Our reference: ECM Ref: 9686471
Contact: Gavin Cherry
Telephone: (02) 4732 8125

3 September 2021

Replacement Response to Environmental Impact Statement: SSD-22191322 Oakdale West Estate Stage 5 at 2 Aldington Road, Kemps Creek

4E Site & Warehouse Plan

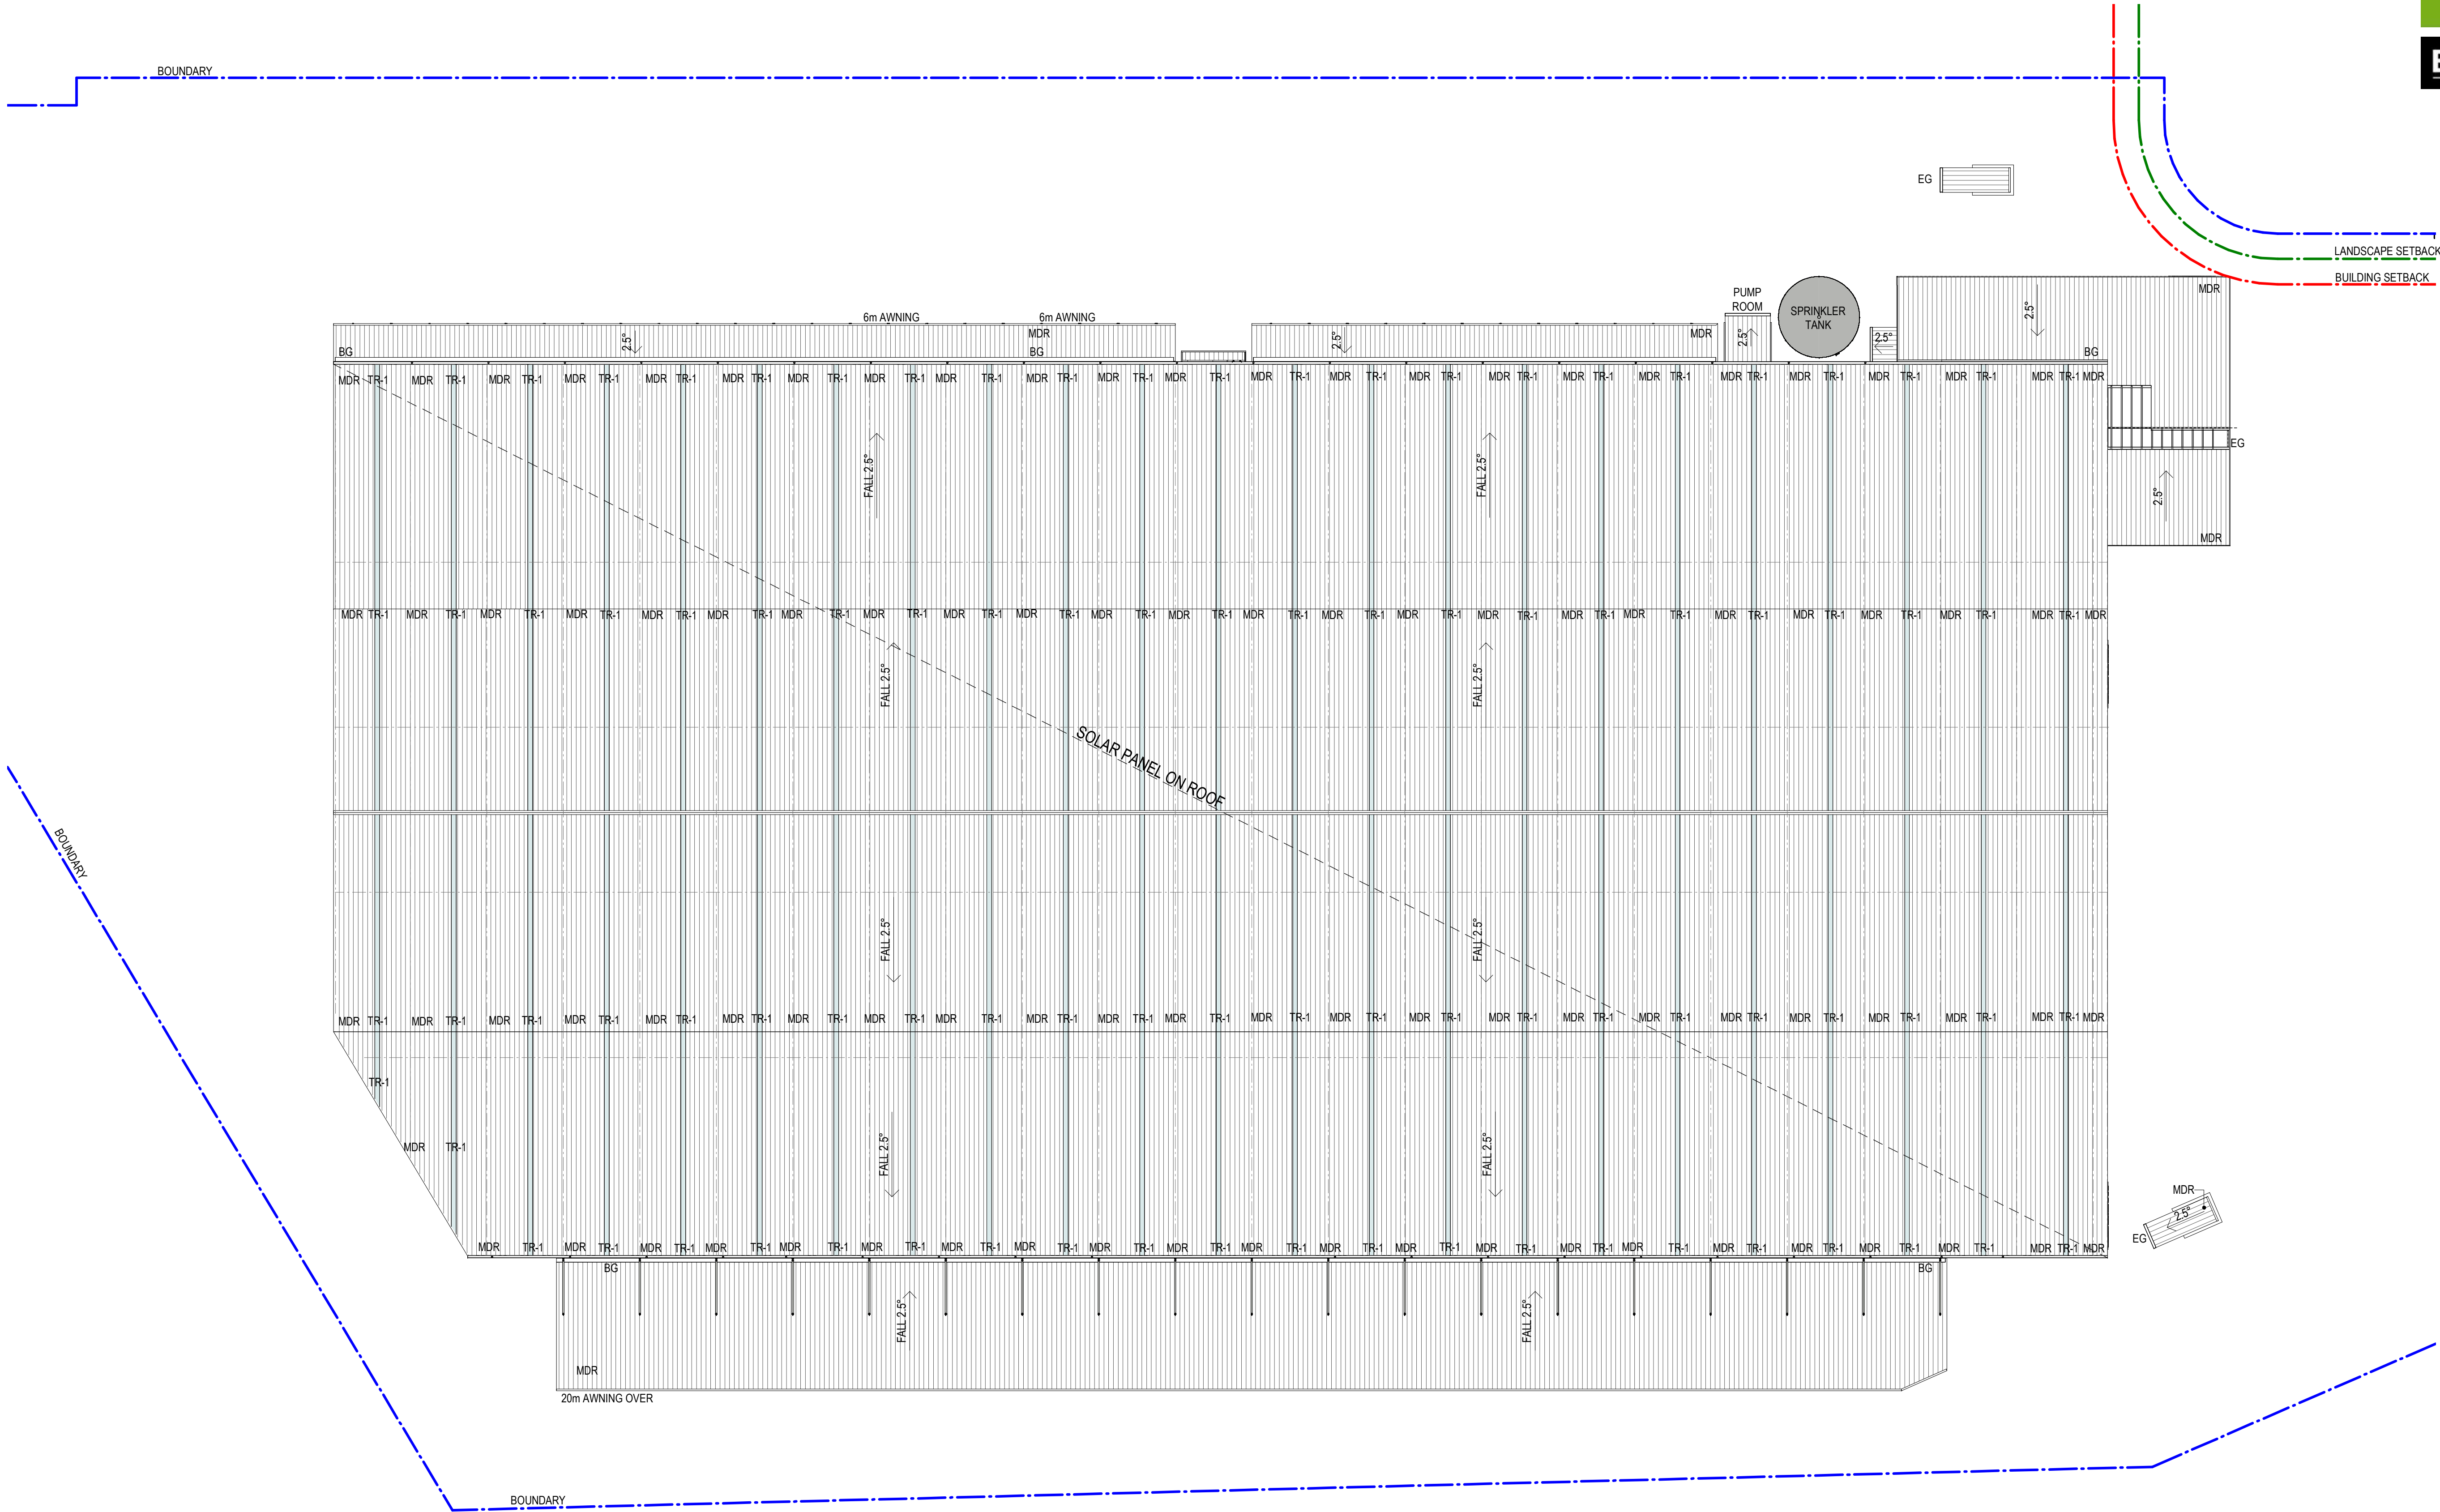
- The applicant is proposing for B-Doubles and B-Triples to access the site which are Restricted Access Vehicles that must only travel on approved routes or require permits from the National Heavy Vehicle Regulator. The swept paths provided by the applicant demonstrate that the B-Triples are not able to be accommodated by the current road design layout at a number of locations on the route to the site. The applicant should be required to redesign / reconstruct all affected sections of road to accommodate B-Triple swept paths with required clearances. Alternatively, B-Triple access should be refused / denied.

1 ELEVATION NORTH - WAREHOUSE 1 : 500

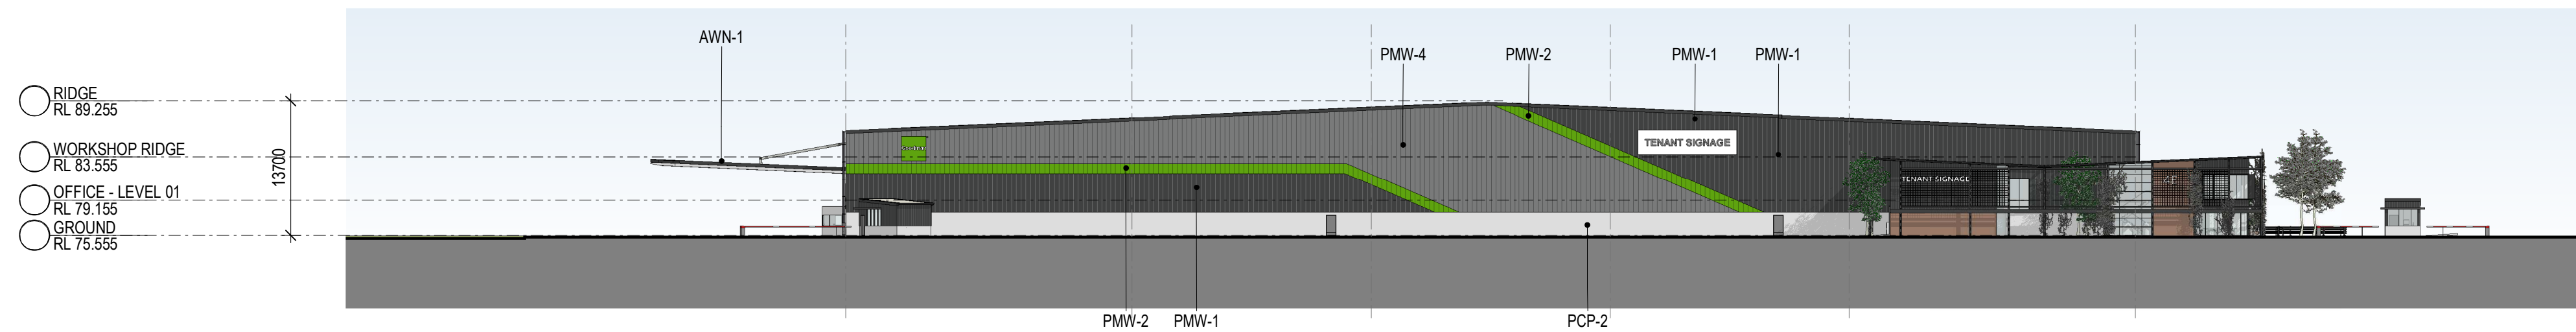
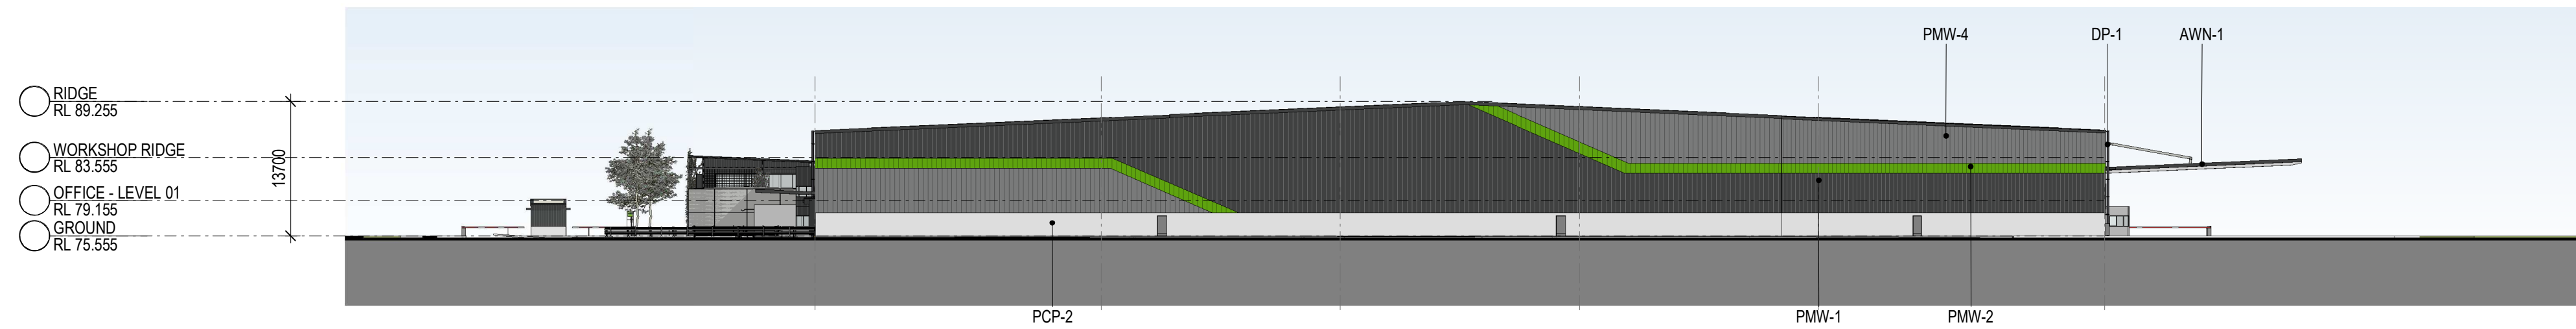
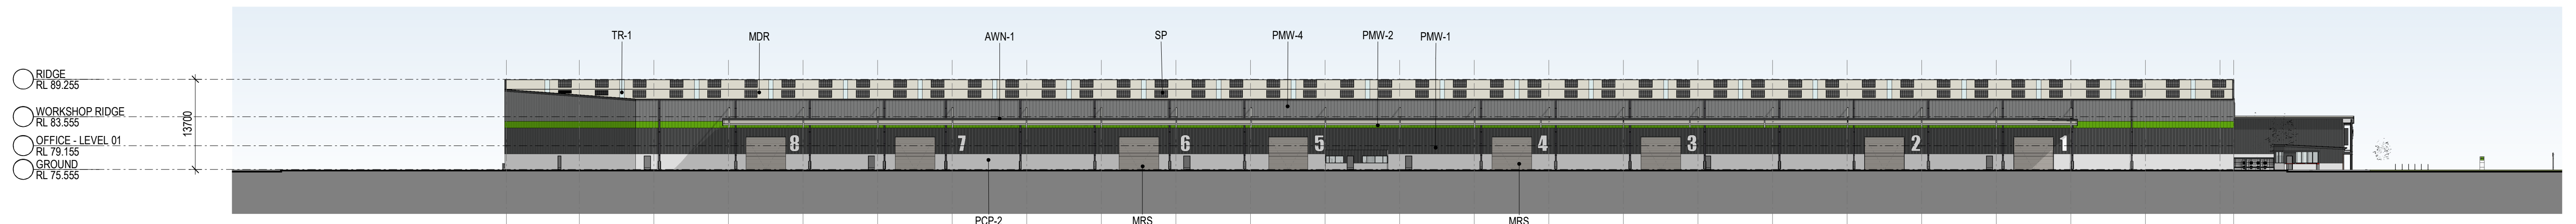
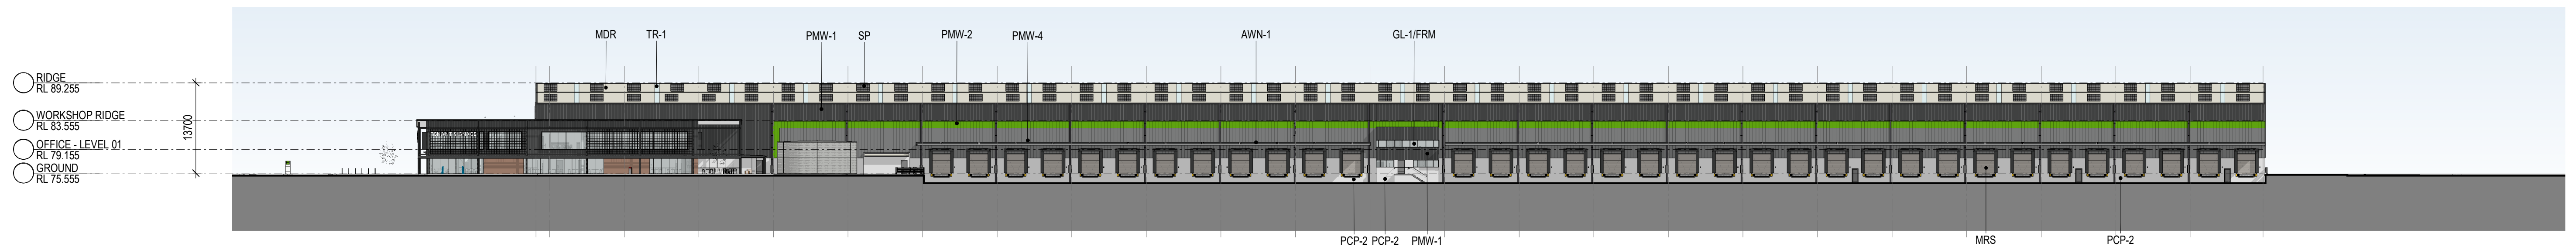
- The plans indicate a maximum Ridge RL of 89.255 and an effective height of 13.7m. While it is appreciated that the method of building height measurement is not expressed in the DCP, it is typical and appropriate practice to measure height above natural ground level and not finished ground level established via a preceding earthworks development application. It is therefore recommended that natural ground levels (predating the approval of altered grounds levels) should be reflected on a revised elevation or section drawing to then confirm if the DCP requirements have been met.
